Re: Certification Submittal for Final Building Certificate of Occupancy for  
Johnny Carinos, [F-17 / D63A]  
Northwest Corner of Office Blvd. and I-25 Frontage Road  
Engineer's Stamp Dated 10/28/04

**Re: JOHNNY CARINO'S**  
**Northwest Corner of Office Blvd. and I-25 Frontage Road**  
**Approval of Permanent Certificate of Occupancy (C.O.)**  
**Engineer's Stamp dated 12/19/2003 (F-17/D063A)**  
**Certification dated 10/28/2004**

**Re: Johnny Carino's Grading and Drainage Plan  
Engineer's Stamp 12-19-03, (F-17/D63A)**

JEFFERSON COMMONS II JOHNNY CARINO'S	DRAWN BY MP
	GRADING AND DRAINAGE PLAN	DATE 12-18-2003
Tierra West, LLC 8509 JEFFERSON NE ALBUQUERQUE, NEW MEXICO 87113 (505)858-3100		2395GRB-102403X.DWG
RONALD R. BOHANNAN P.E. #7868		SHEET # 2 OF 6
		JOB # 230095

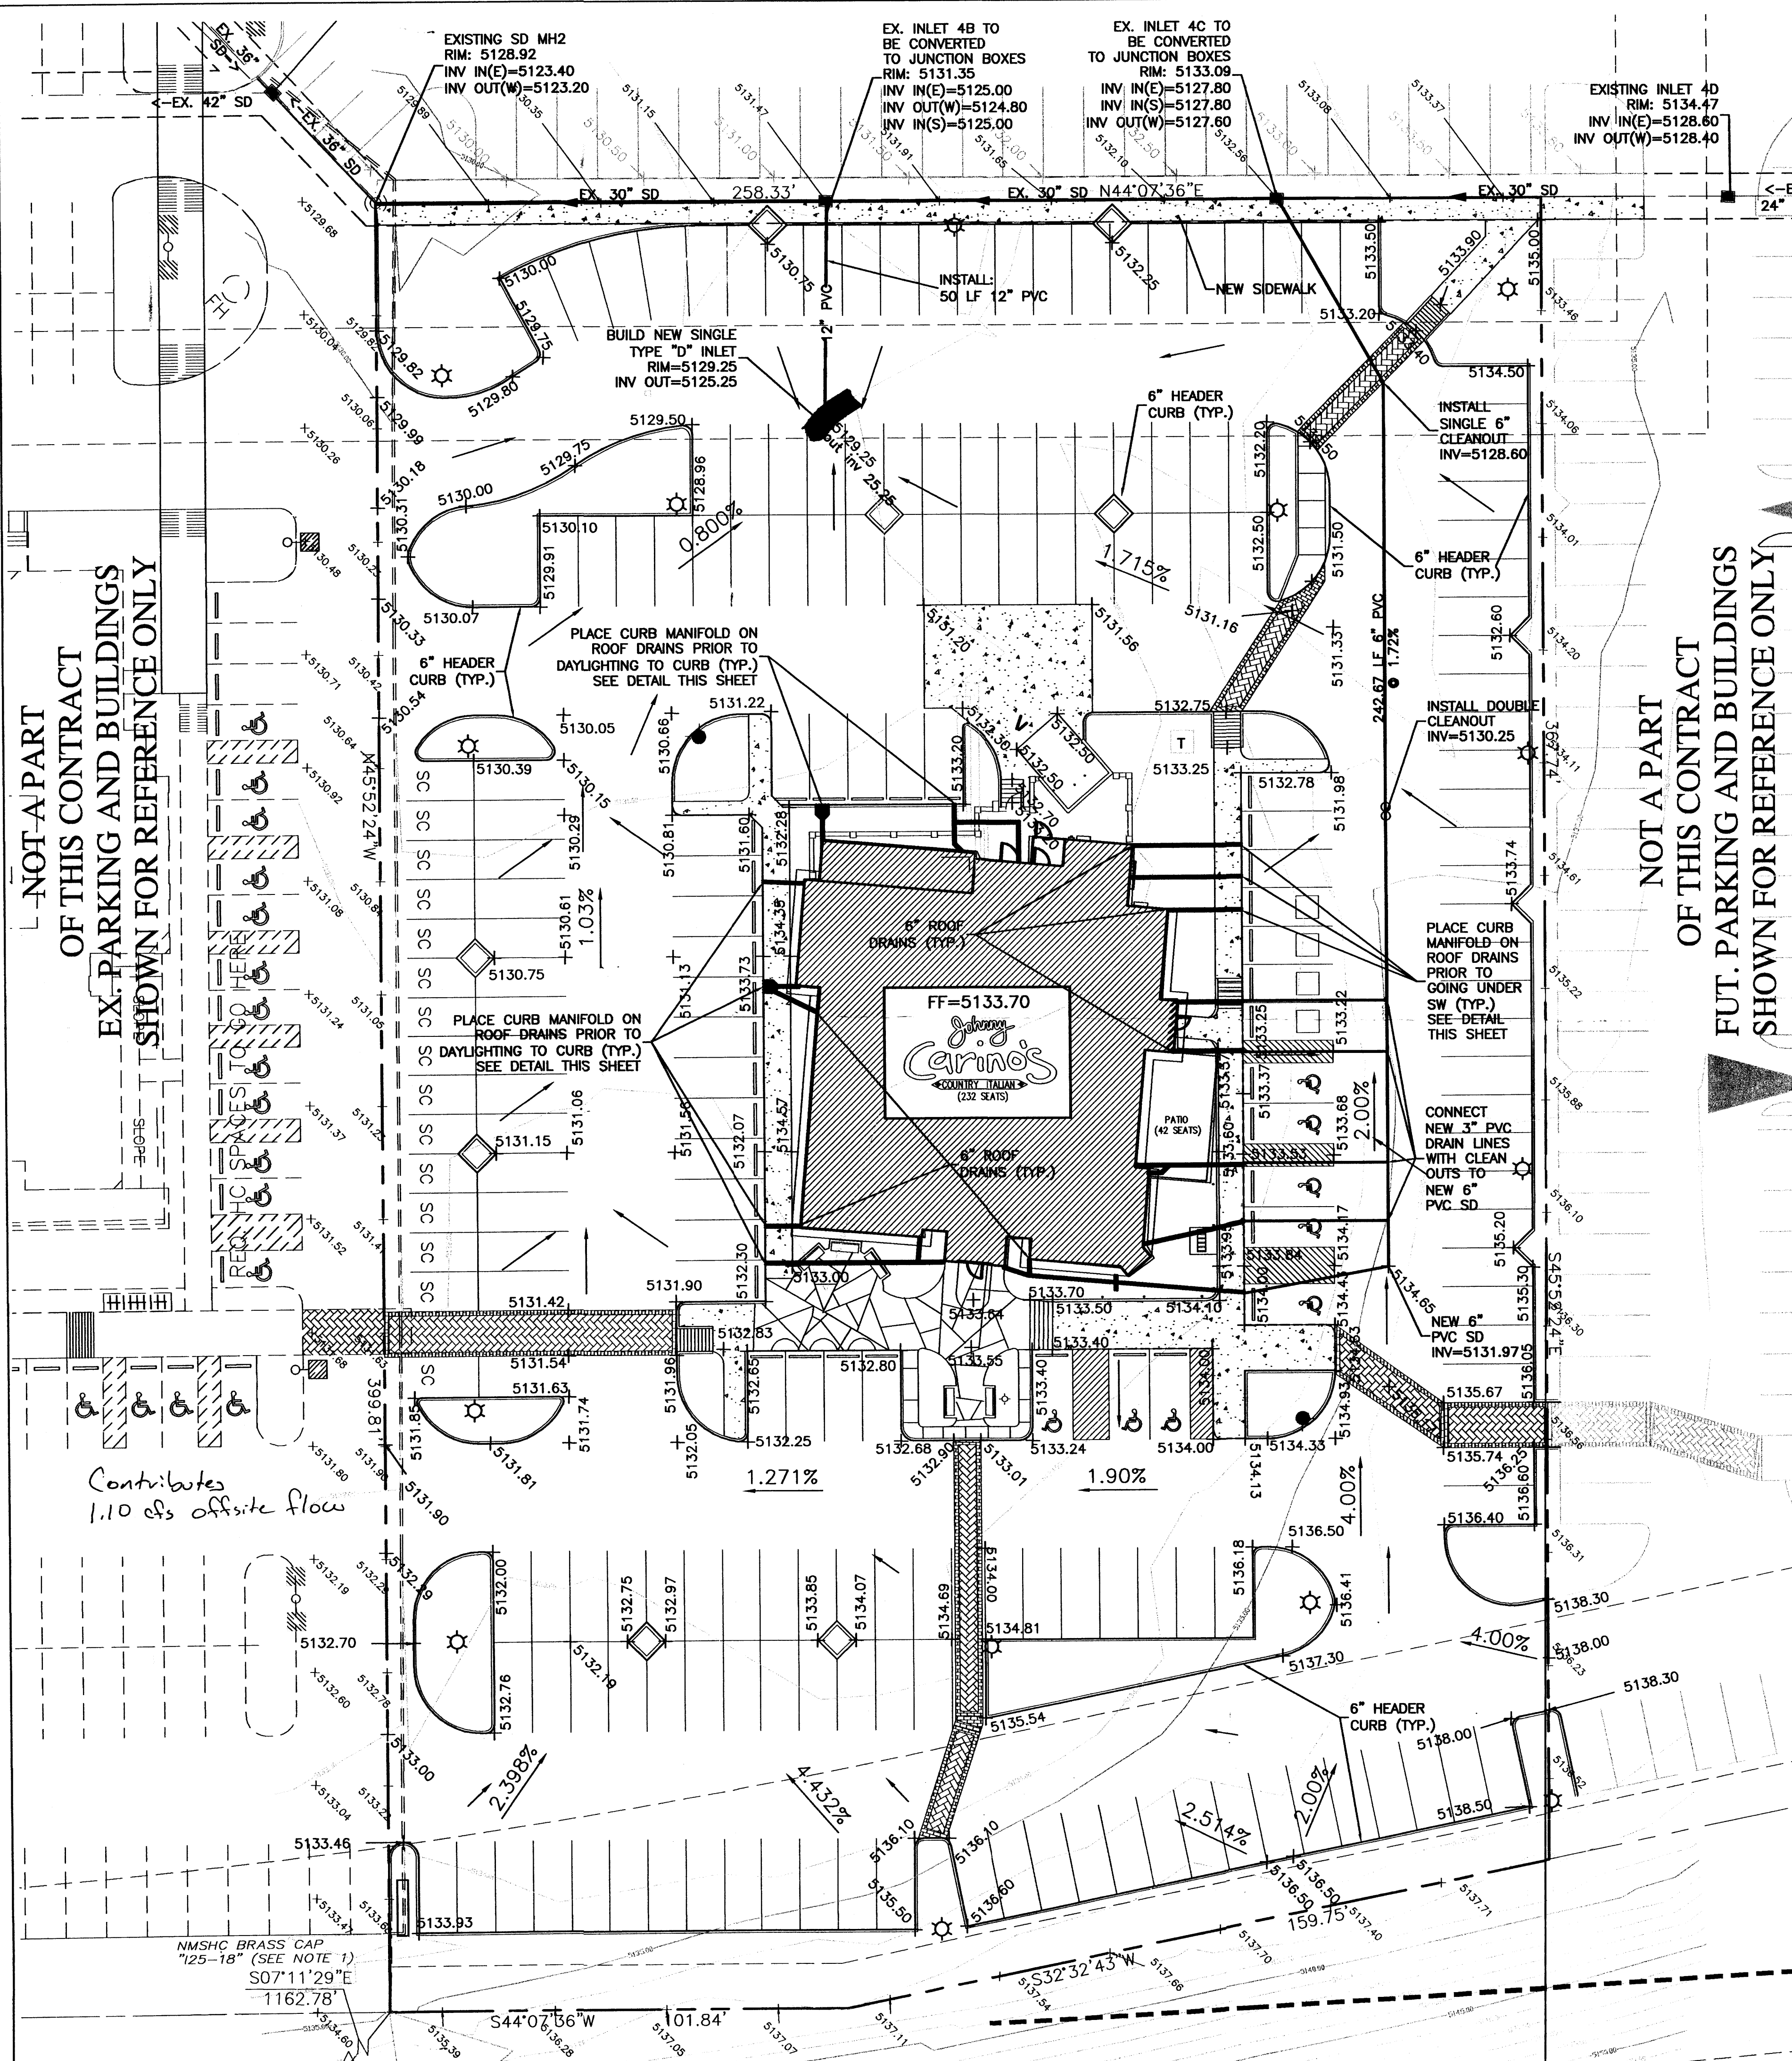
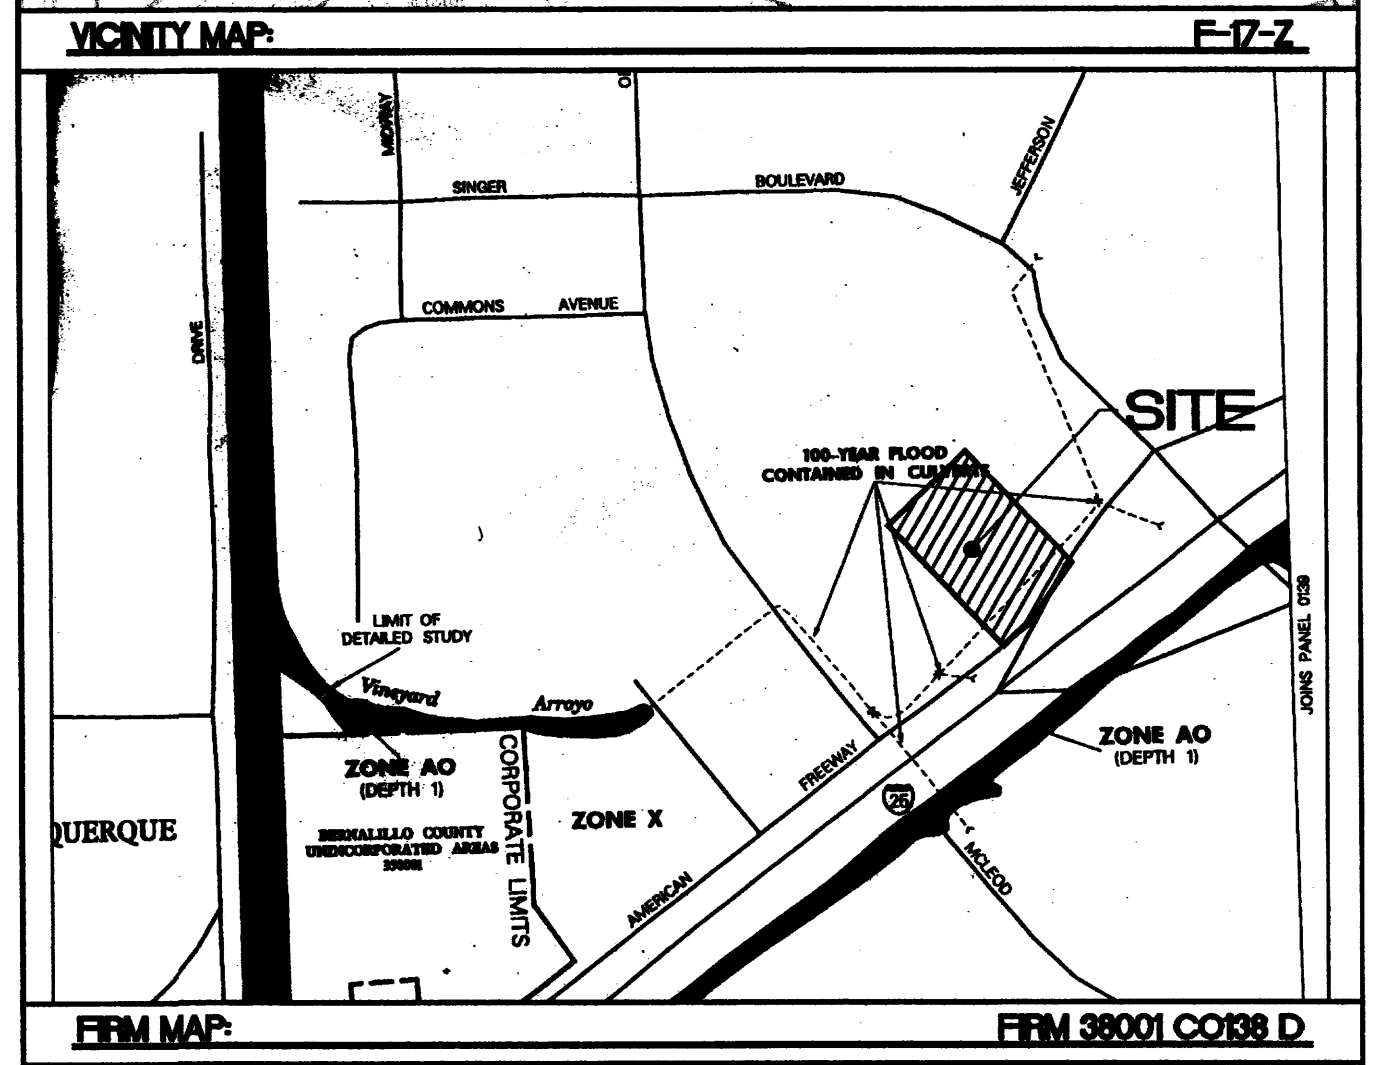
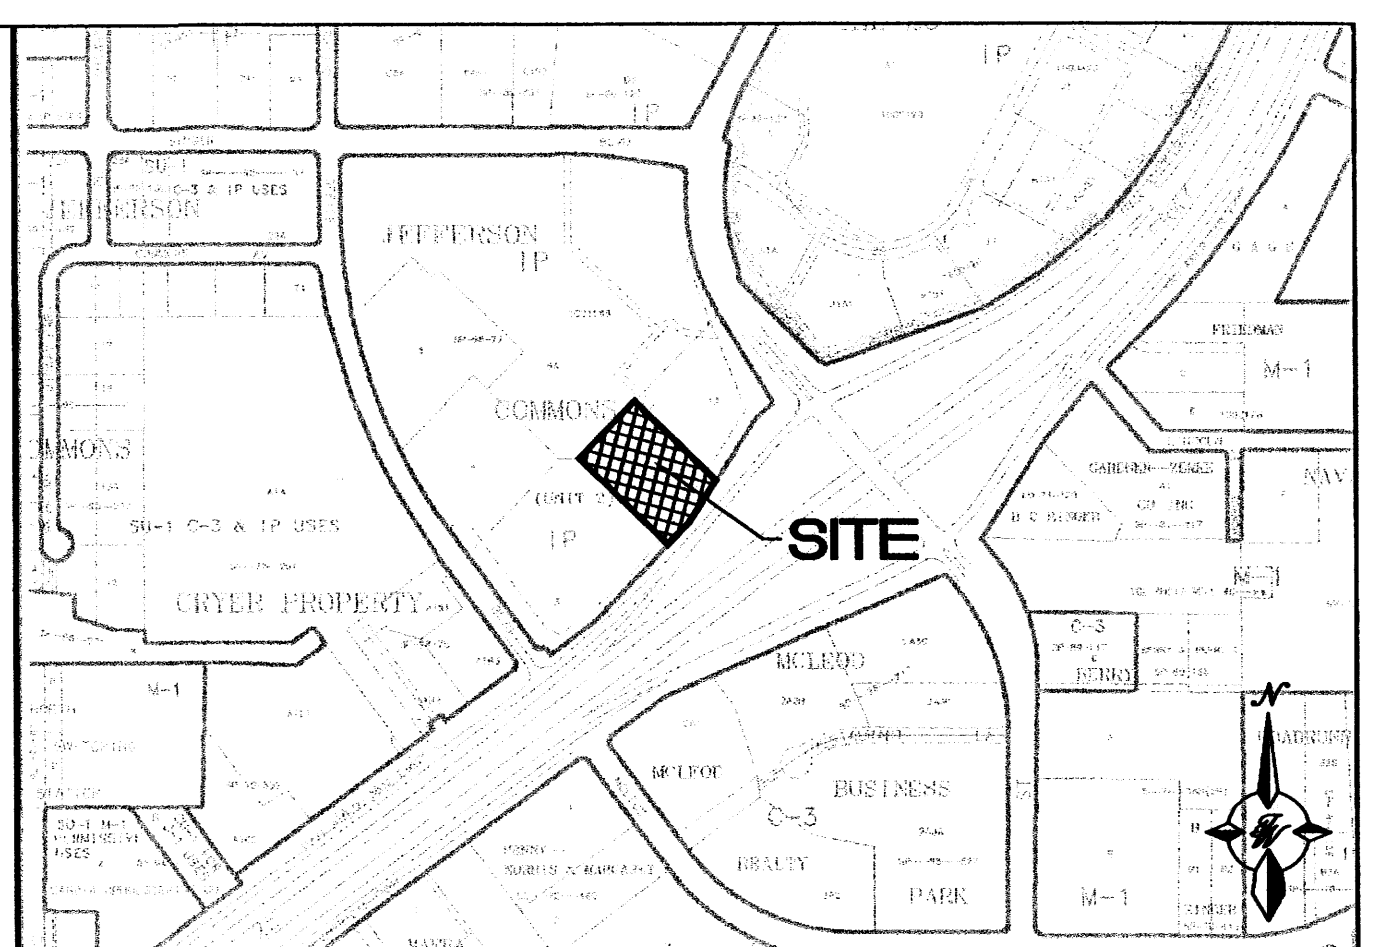
- Are there any offsite flows? If so, please quantify.
- Please quantify runoff and indicate the amount of runoff draining to drop inlet.

In response to your letter dated January 22, 2004, ~~this site does receive a small amount of flow from the adjacent restaurant site to the southwest. The amount of this flow is 1.10 cfs.~~ A portion of the roof drains directly to a storm sewer system that is connected to the existing storm sewer system running along the northwest property line. The amount of flow generated by this portion of the roof is 0.32 cfs. The remainder of the site generates 9.74 cfs, which combined with the 1.10 cfs from off-site, drains to the drop inlet in the northwest parking lot. A calculation page is enclosed quantifying the runoff generated by this site.
